Please ask for: Mrs D Johnson  
Email: [daun.johnson@arun.gov.uk](mailto:daun.johnson@arun.gov.uk)  
Telephone: 01903 737762  
Our Ref: BR/63/22/PL  
Your Ref:  
Date: 12th April 2022

**Application for Planning Permission**

**Development:** Change of use of 5 No self-contained flats for adults with learning difficulties to 5 No self-contained flats and formation of 5 No further flats from HMO rooms, garage and office, repairs and decoration of external surfaces, minor alterations to elevation facing Sadler Street, change one window facing rear courtyard to French doors & apply obscure film to 2 windows in courtyard area. This application affects the setting of listed buildings, affects the character & appearance of The Steyne Conservation Area and is in CIL Zone 4 (Zero Rated) as flats.

**Location:** Salisbury House The Steyne Bognor Regis PO21 1TX

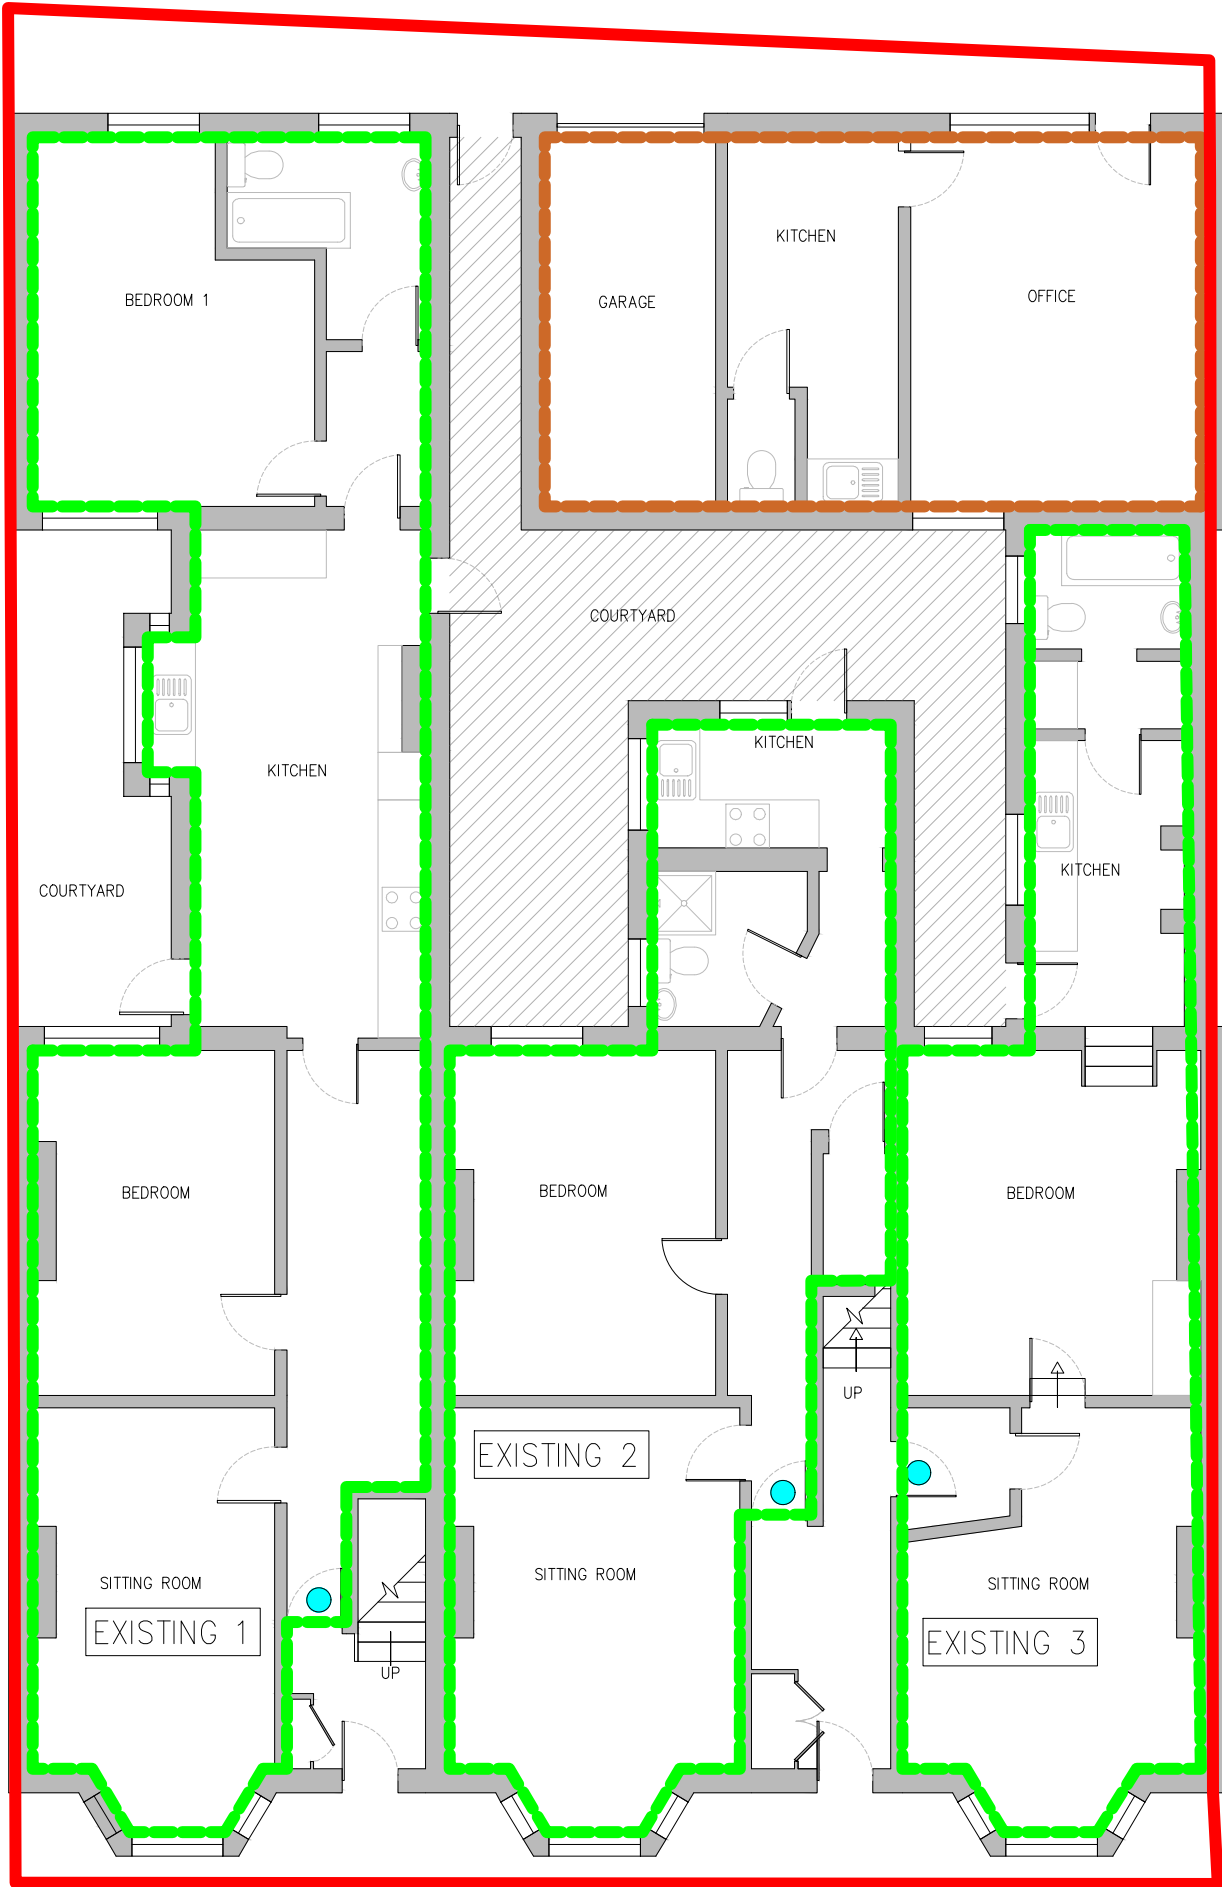
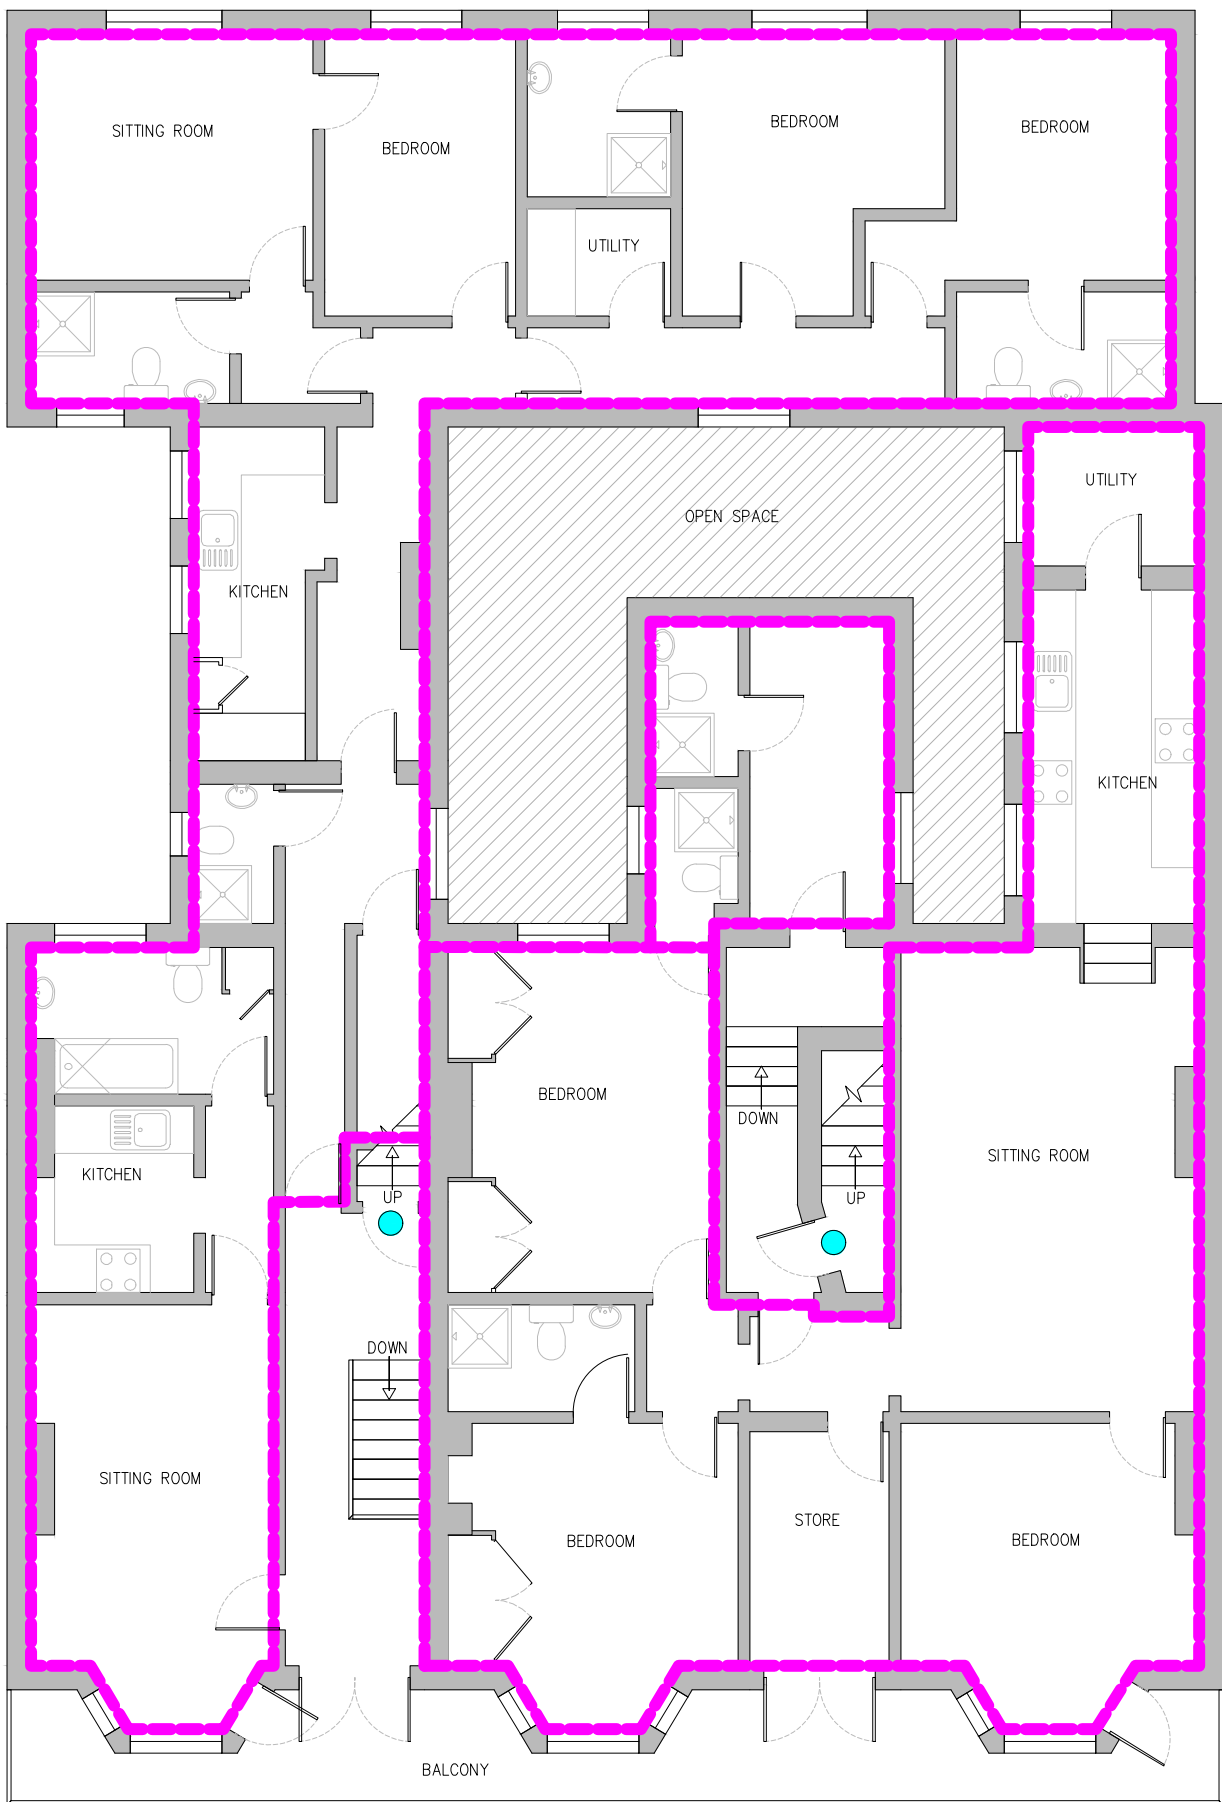
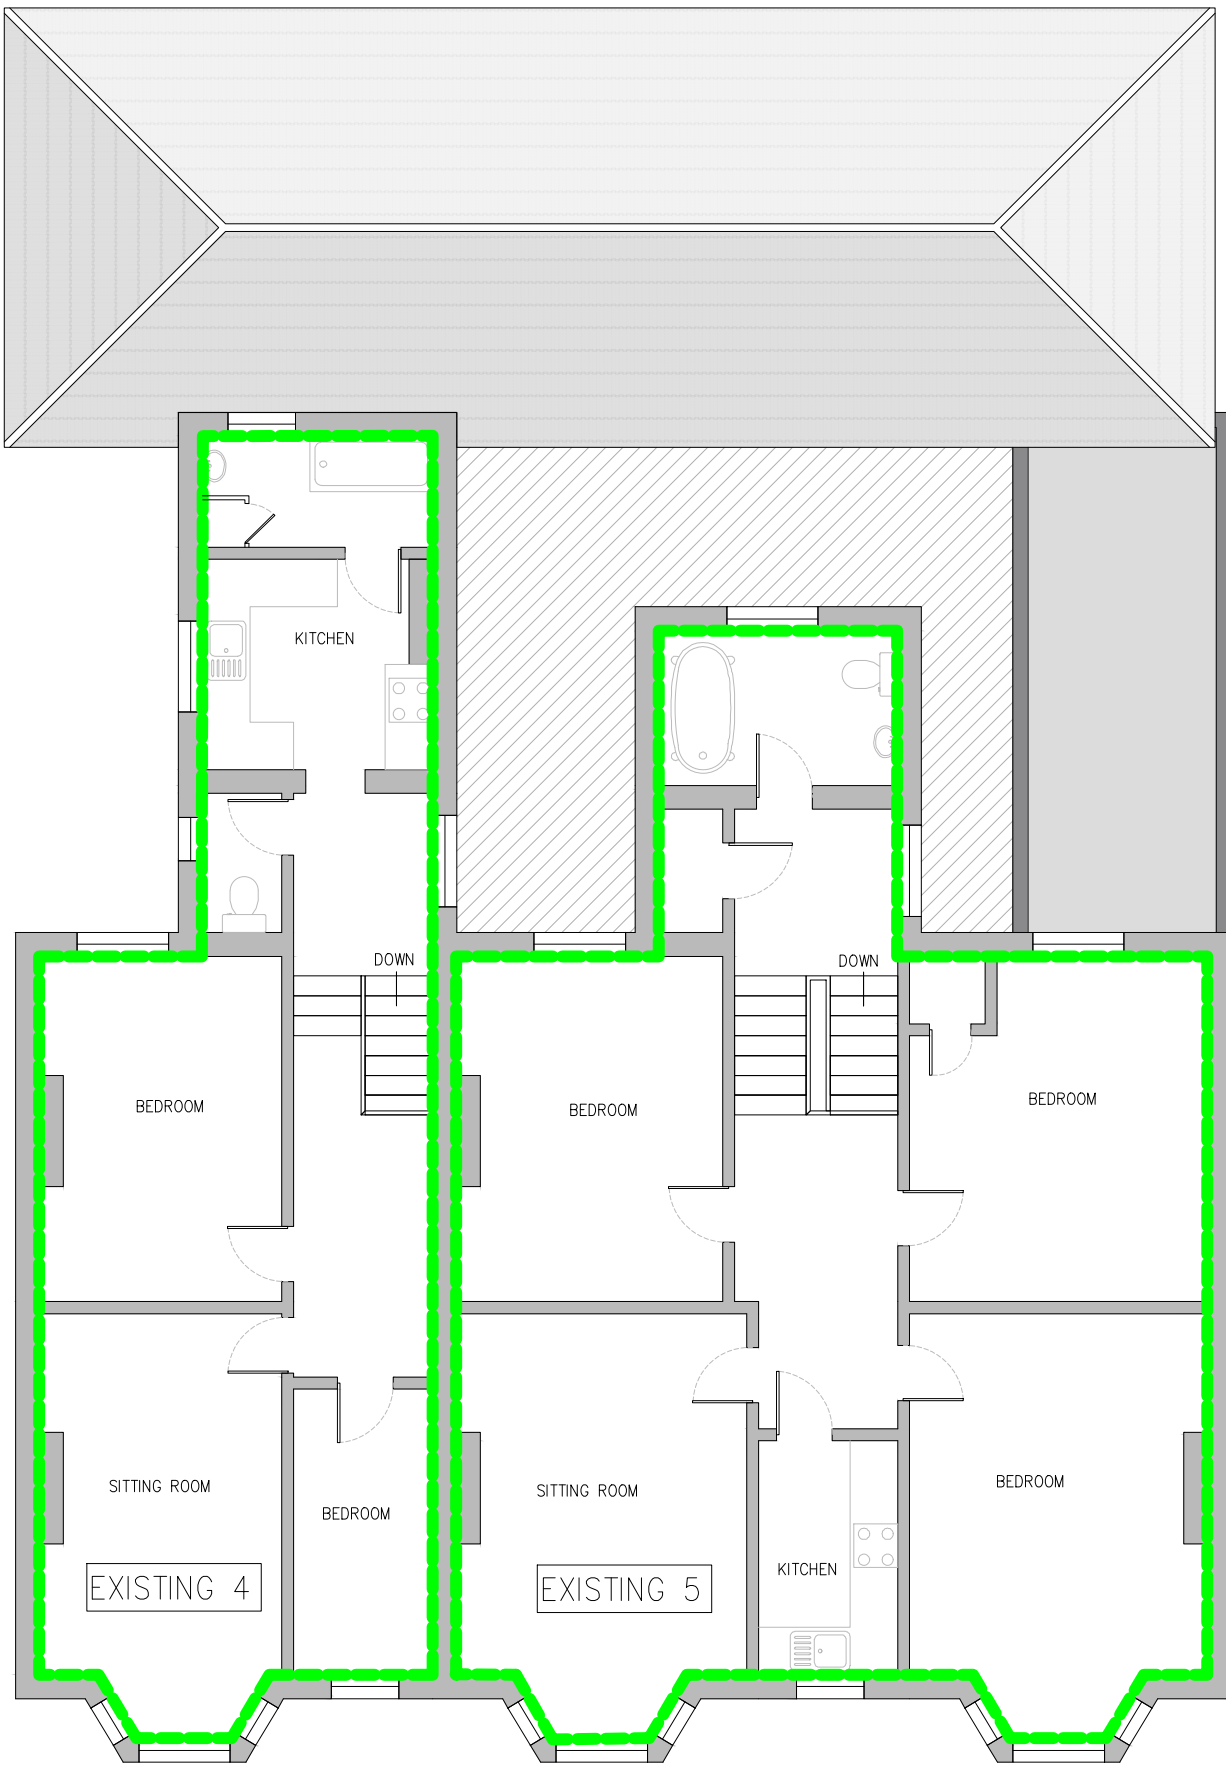
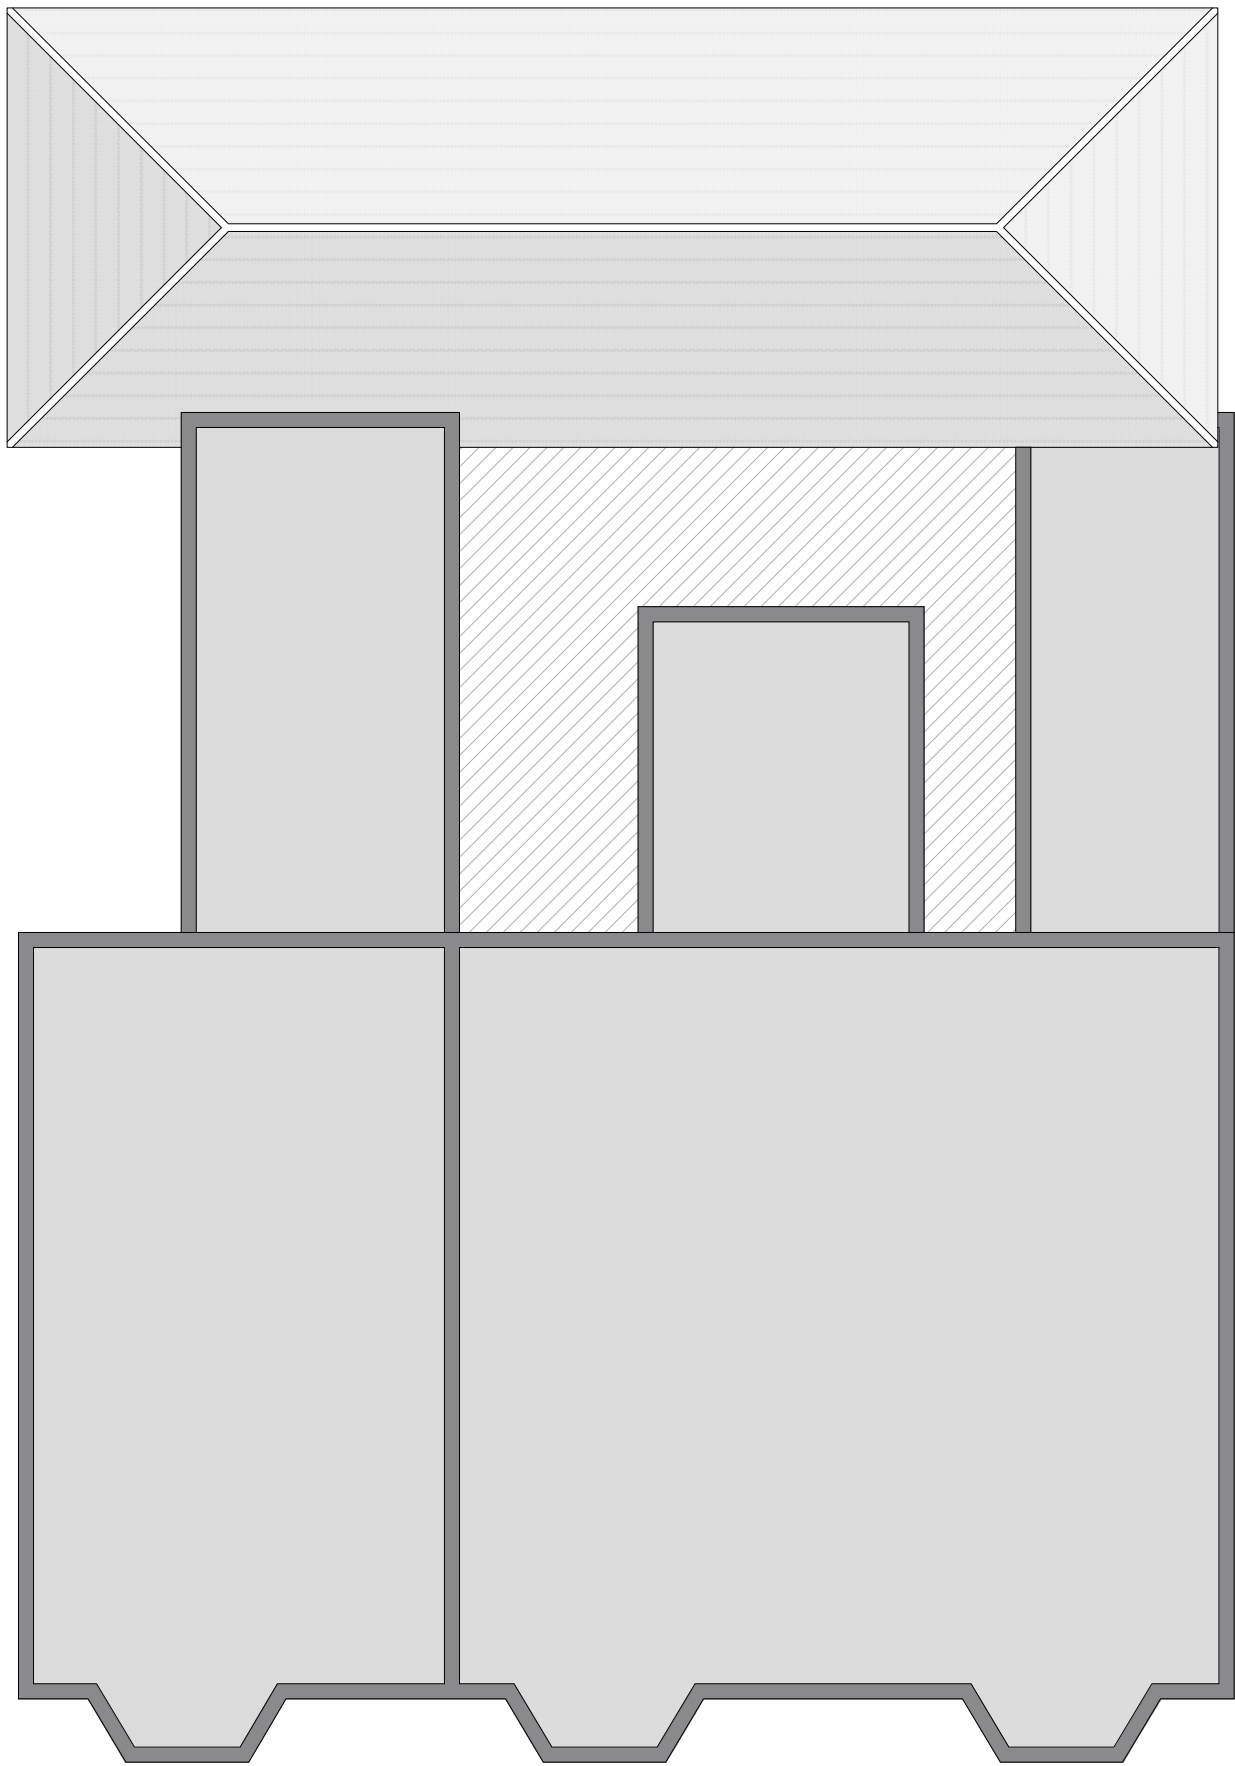
In the description of the proposed works 'change of use of 5 self contained flats with learning difficulties to 5 self contained flats', however, the existing floor plan shows no self contained flats. Please clarify.
